We have the following comments regarding this application to discharge drainage conditions.

Condition 6 – Surface Water Drainage Design

Application No: BN/57/20/DOC
Registered: 3rd June 2020
Site Address: Land Rear of Lillies Yapton Road Barnham PO22 0AY
Description of Works: Approval of details reserved by condition imposed under ref BN/32/15/OUT relating to Condition Nos 6 - surface water drainage, 7 - discharge flows, 8 - SudS, 9 - future access & maintenance of any watercourse and 10 - surface water drainage

TITLE YAPTON ROAD  
BARNHAM  
DETAILS SUDS CROSS SECTION

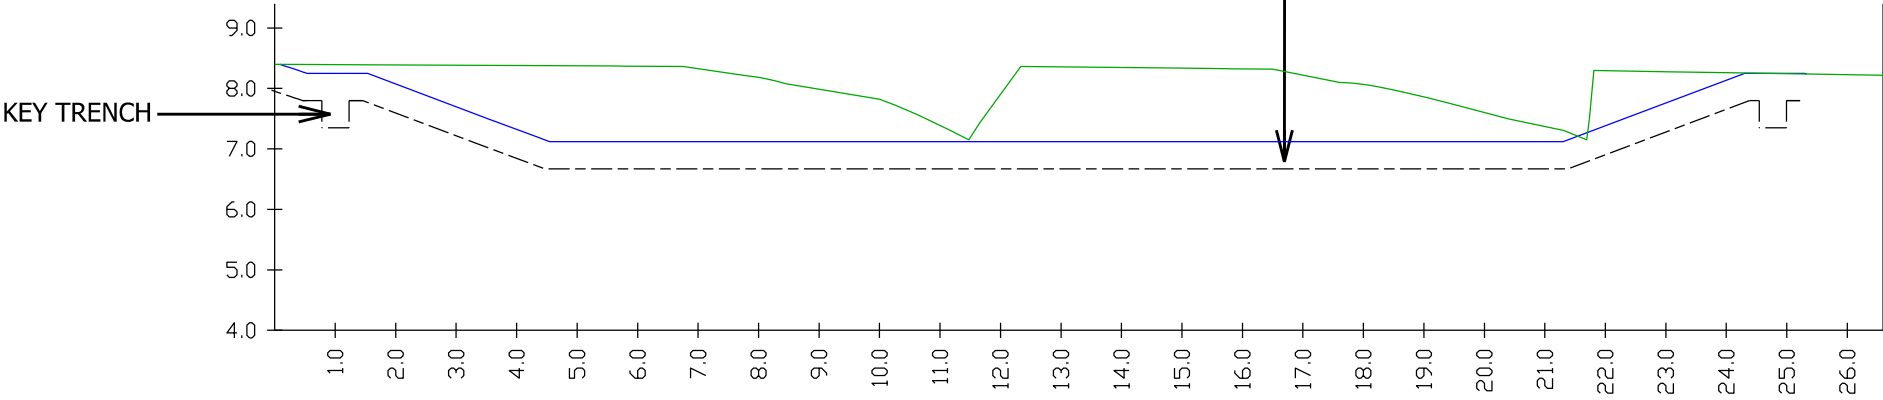
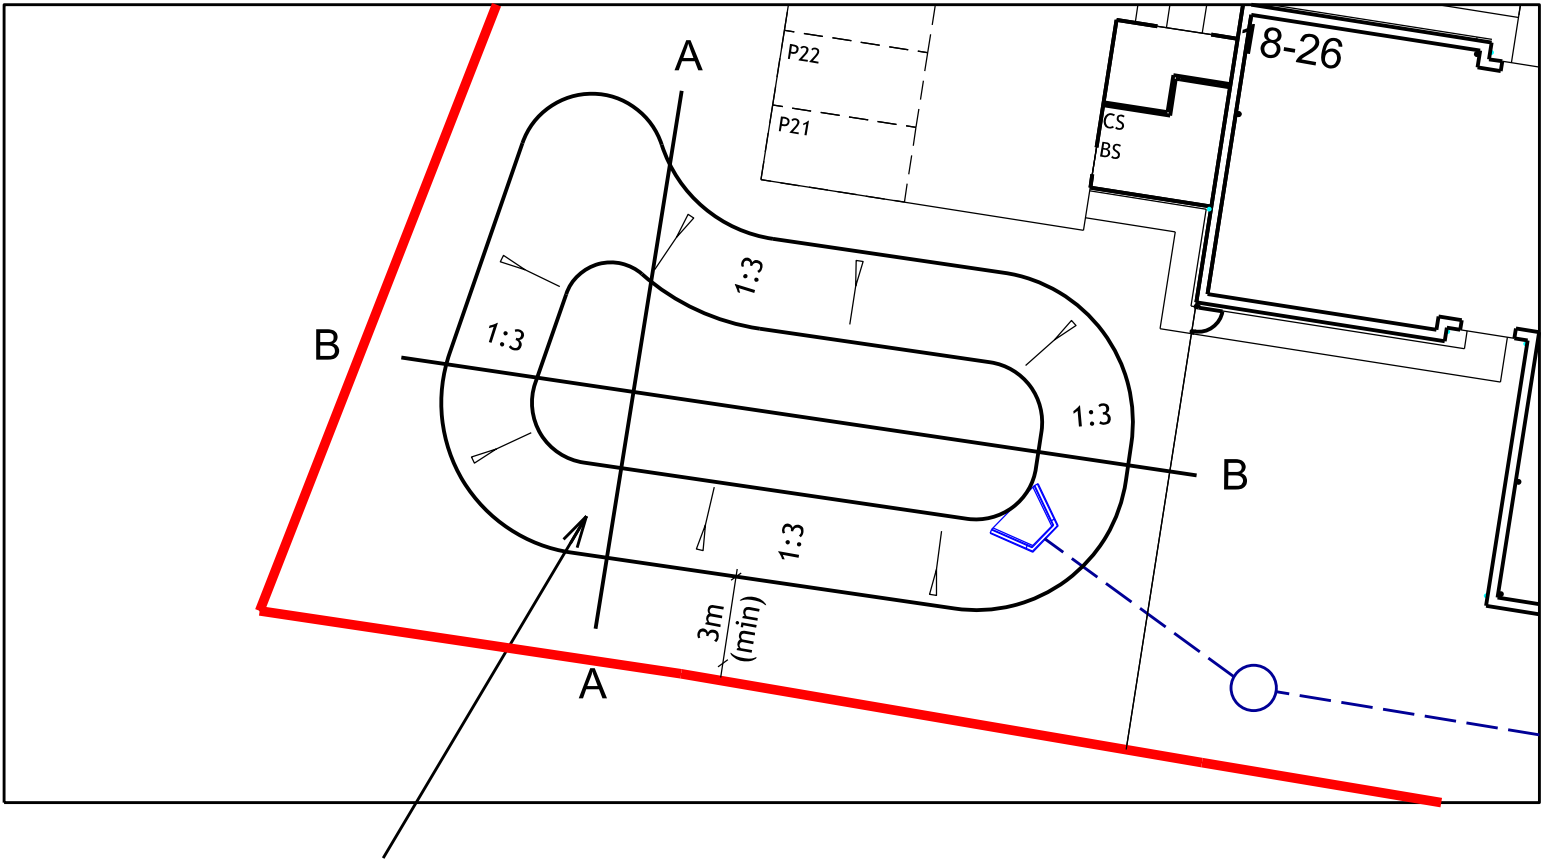
9. Pond cross section construction detail drawings are required- 2 sections required, perpendicular to one another. Details should include liner.
10. Flotation calculations required. Please provide winter groundwater monitoring October- March. Otherwise, assume groundwater is at surface.

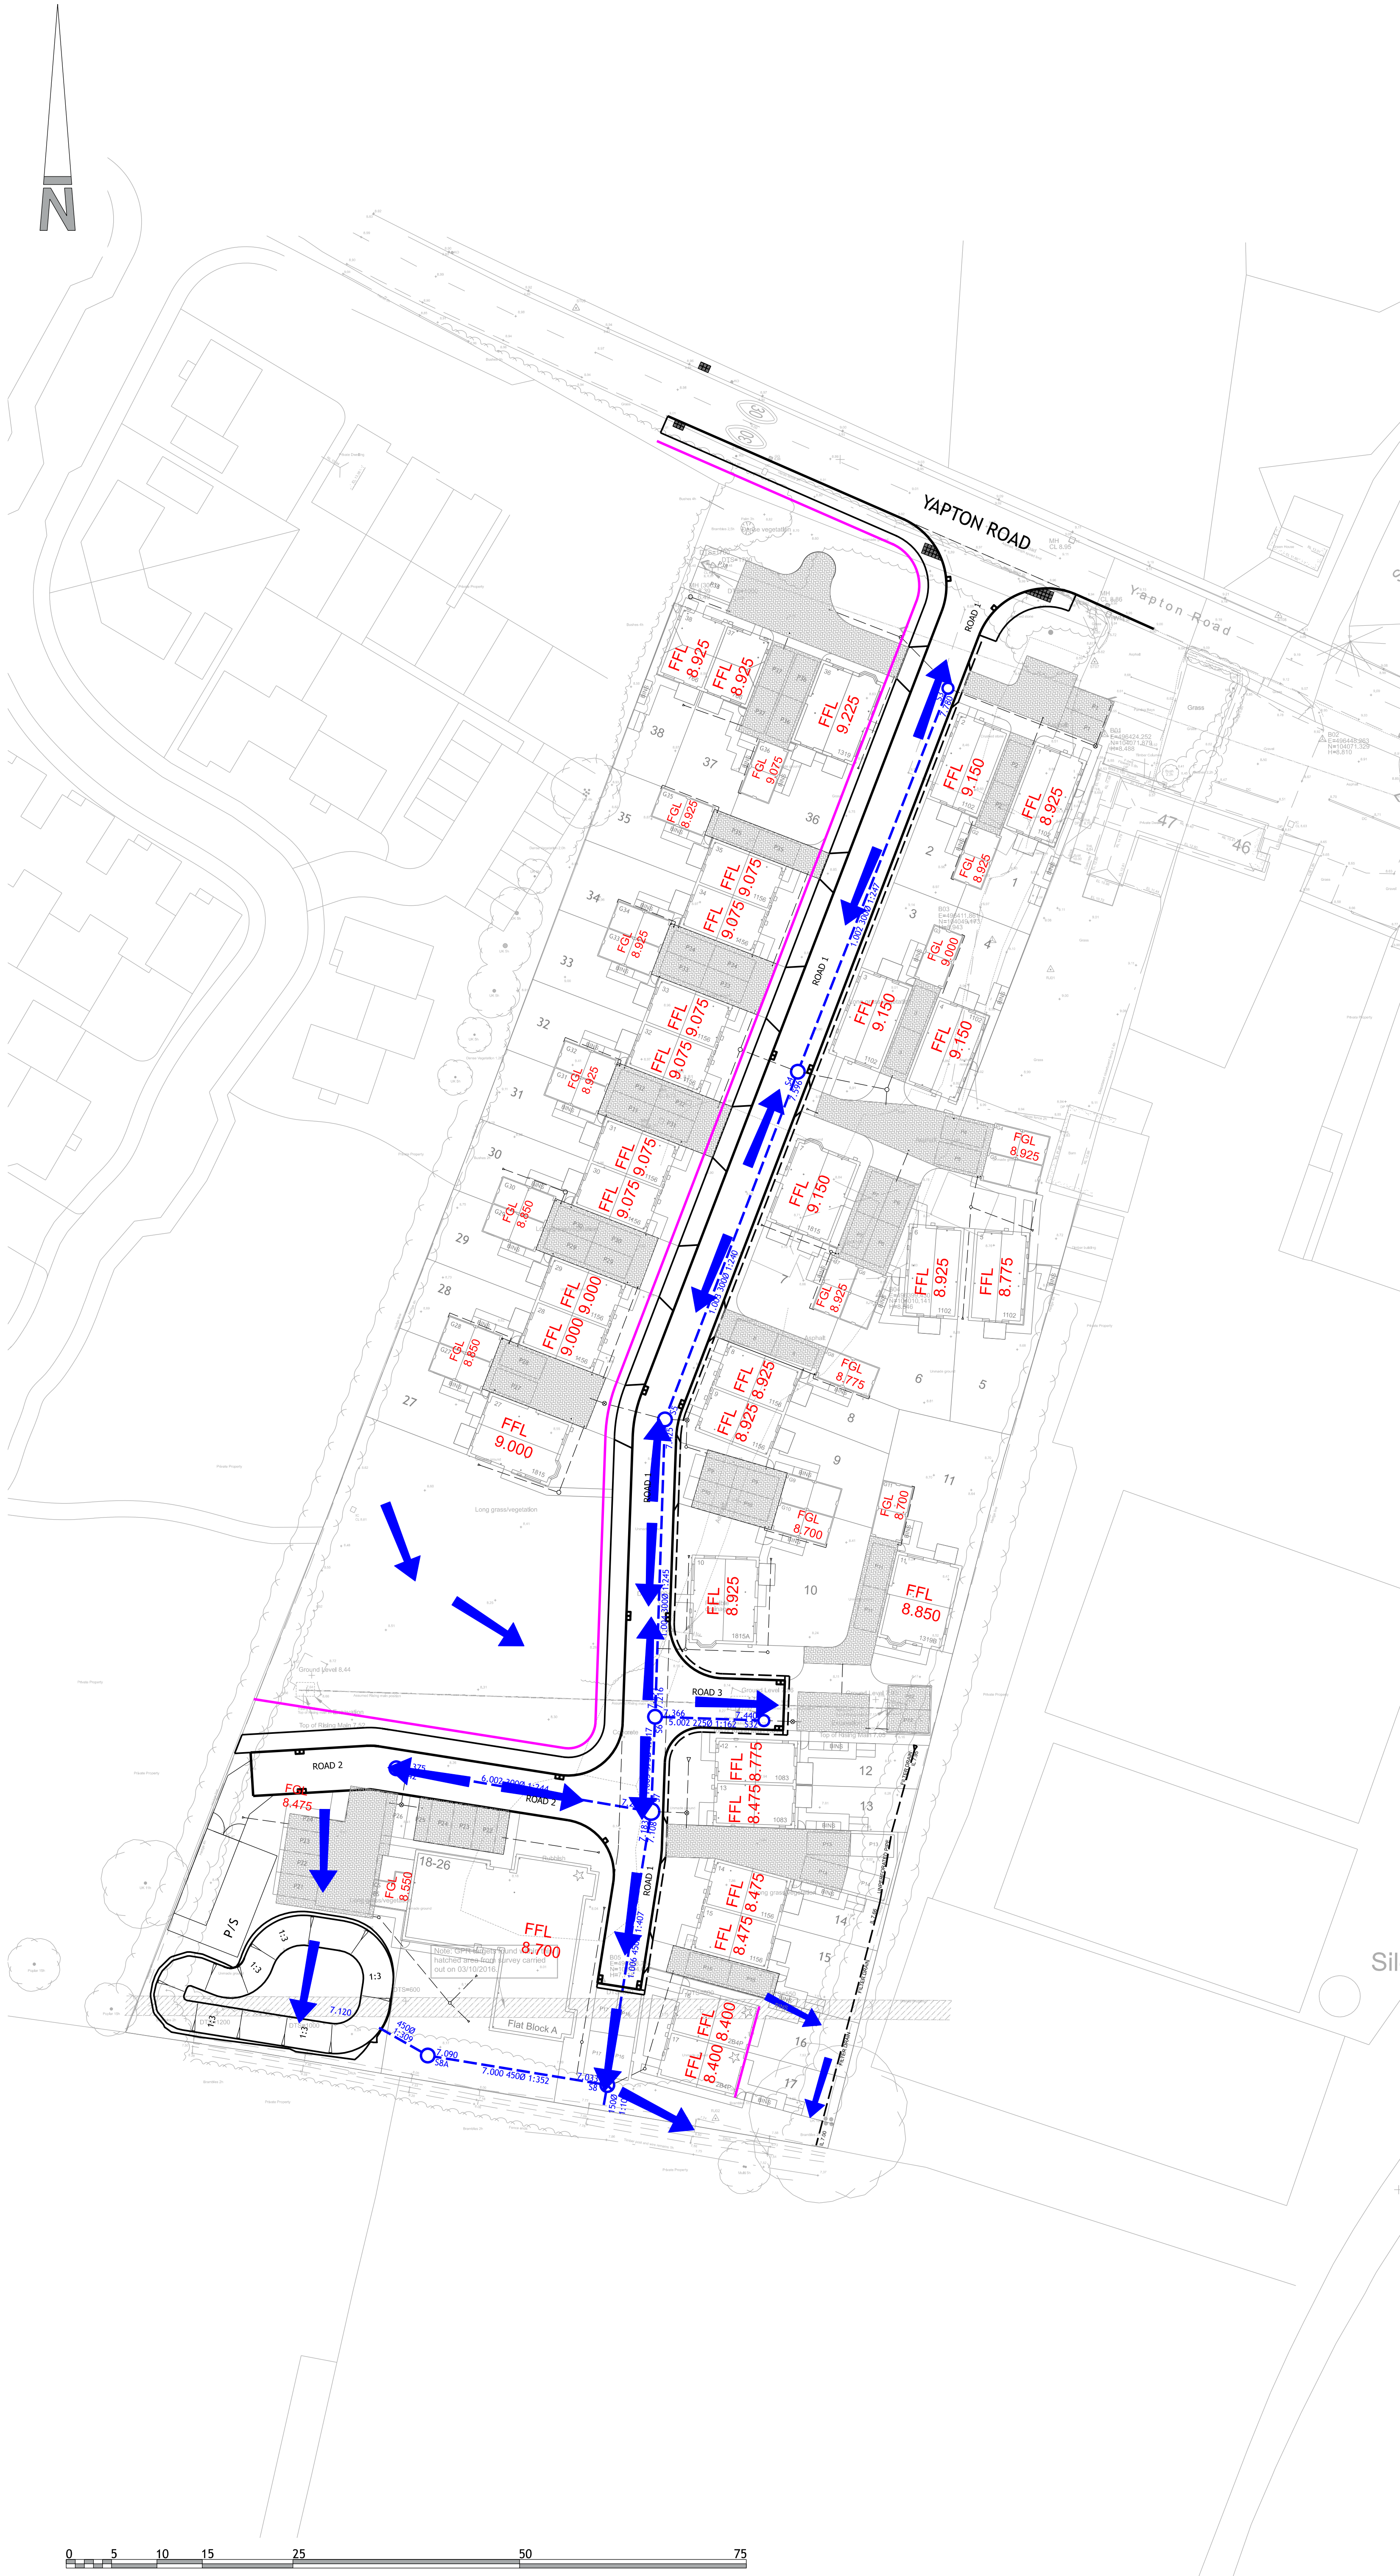
2. A surcharged outfall should be modelled with water levels at top of ditch.
3. No consistency between orifice invert levels on plan and those shown on drawings. Please update calculations or drawings.
